CITY OF ALBUQUERQUE

**Re: Dave and Busters Winrock
Conceptual Grading and Drainage Plan
Engineer's Stamp Date –sealed but not dated- (J19/D038)**

Based upon the information provided in your submittal received 9-26-13, the above referenced plan cannot be approved for Site Plan for Building Permit by the DRB until the following comments are addressed:

GRADING & DRAINAGE
PLAN

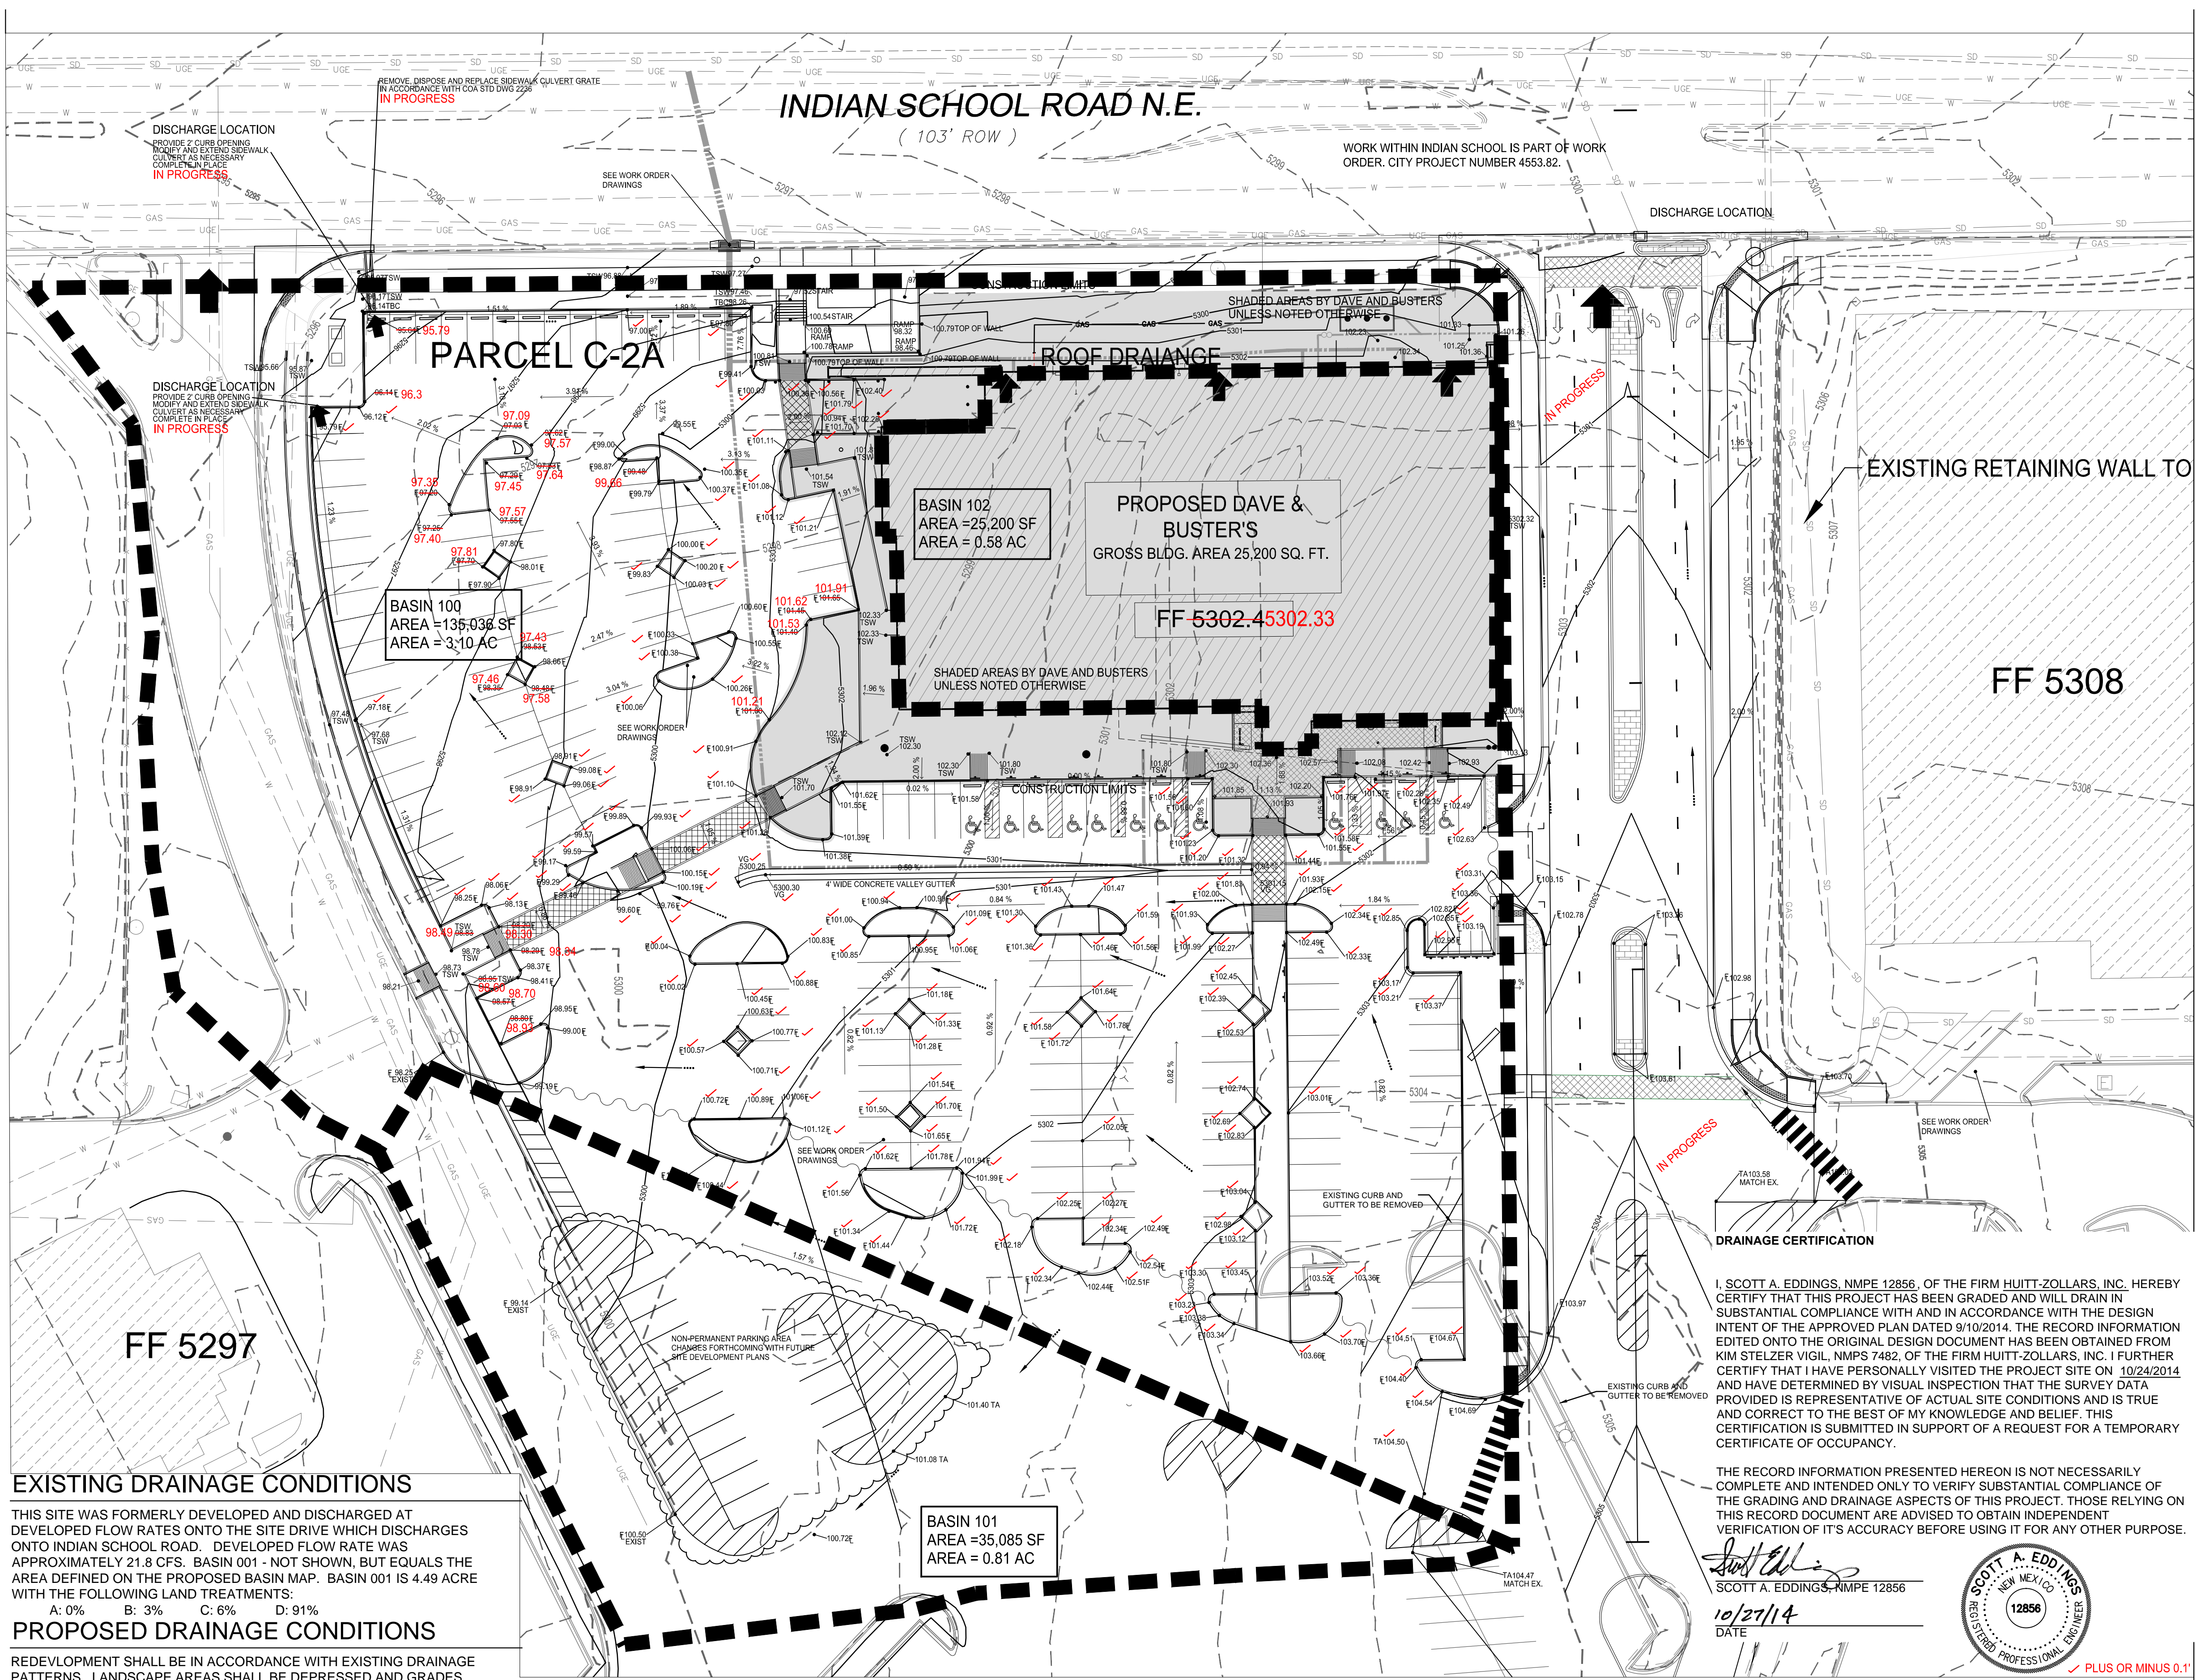
1. Toys-R-Us appears to have a 12" storm drain from their site to the existing inlet in the proposed entrance. It is difficult to tell how this proposed layout will affect it.
2. Storm drains are not to have an angle less than 90 degrees. This plan proposes an angle of 45 degrees.
3. How big is the manhole in Indian School Rd and is there room for another connection?
